JOHNSON ESTATES FILING NO. 1  
COUNTY OF EL PASO, STATE OF COLORADO  
GRADING AND EROSION CONTROL PLAN  
DECEMBER 2020

EPC STORMWATER REVIEW COMMENTS  
IN ORANGE BOXES WITH BLACK TEXT

TITLE SHEET

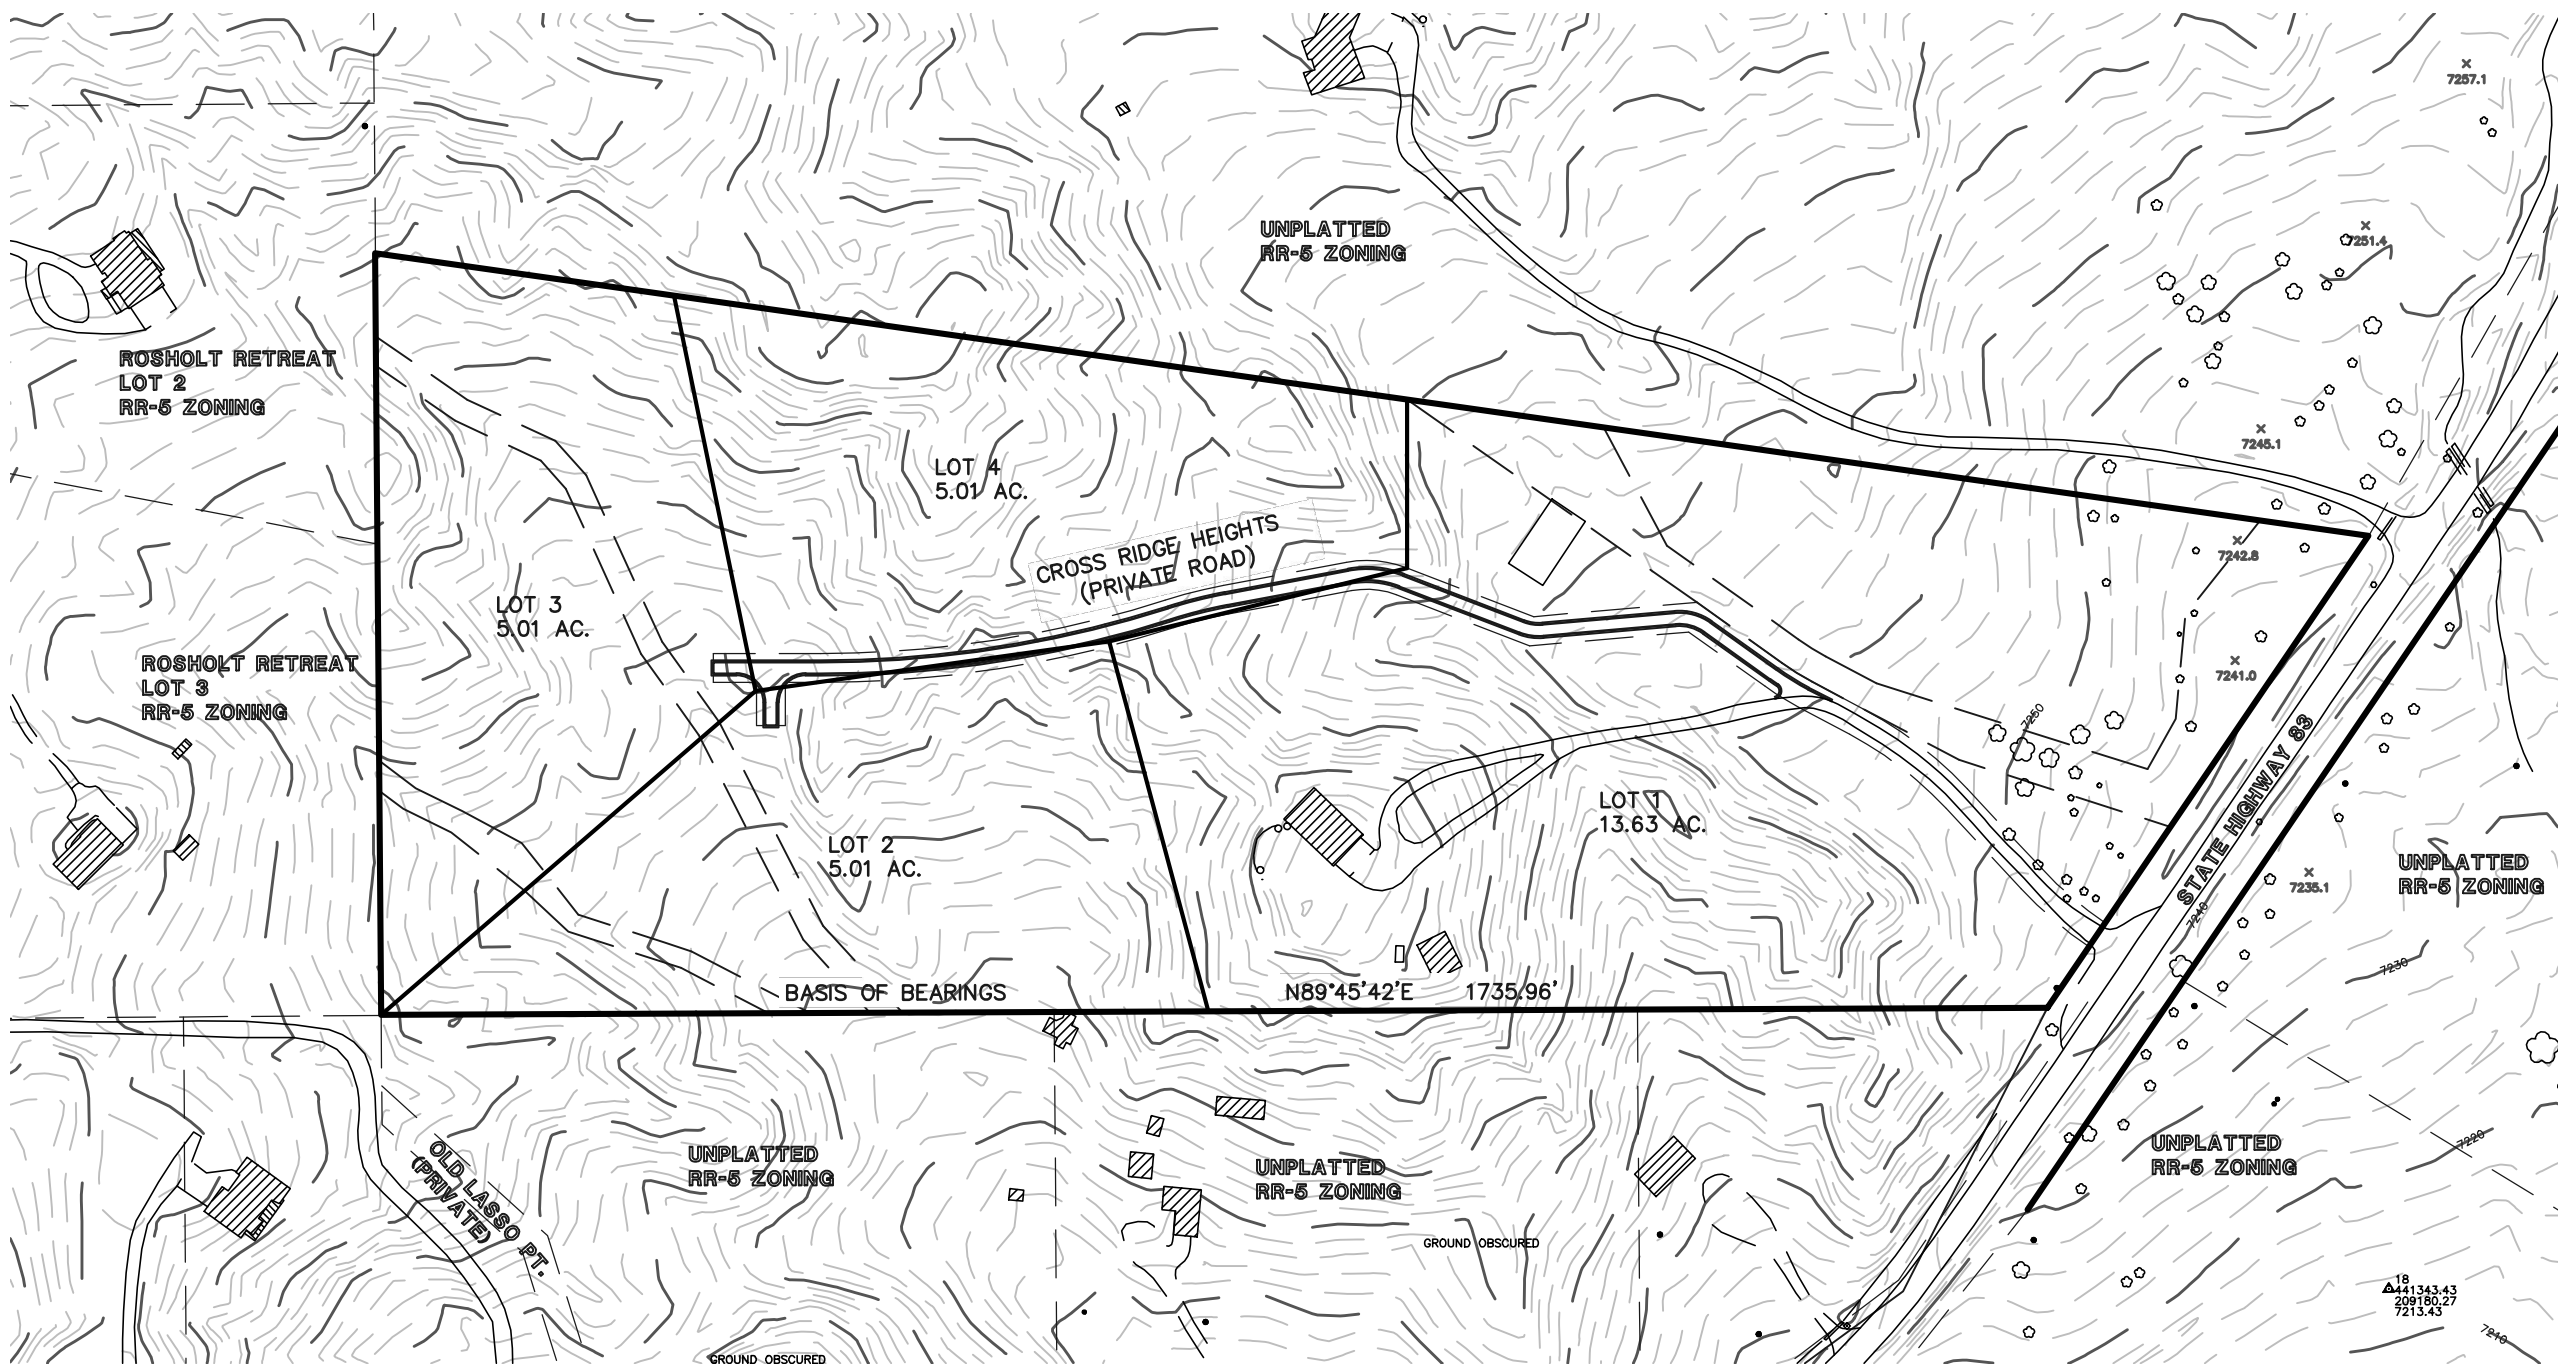
Checklist Item "f" - specify condition of existing vegetation.

Revise to Ms. Lupe Packman  
719-520-7550

Revise to be Statement  
from Checklist Item "ff"

Revise to be Statement  
from Checklist Item "hh"

Please update to  
"PCD File No.  
MS211"

ADDED

REVISED

REVISED

REVISED

REVISED
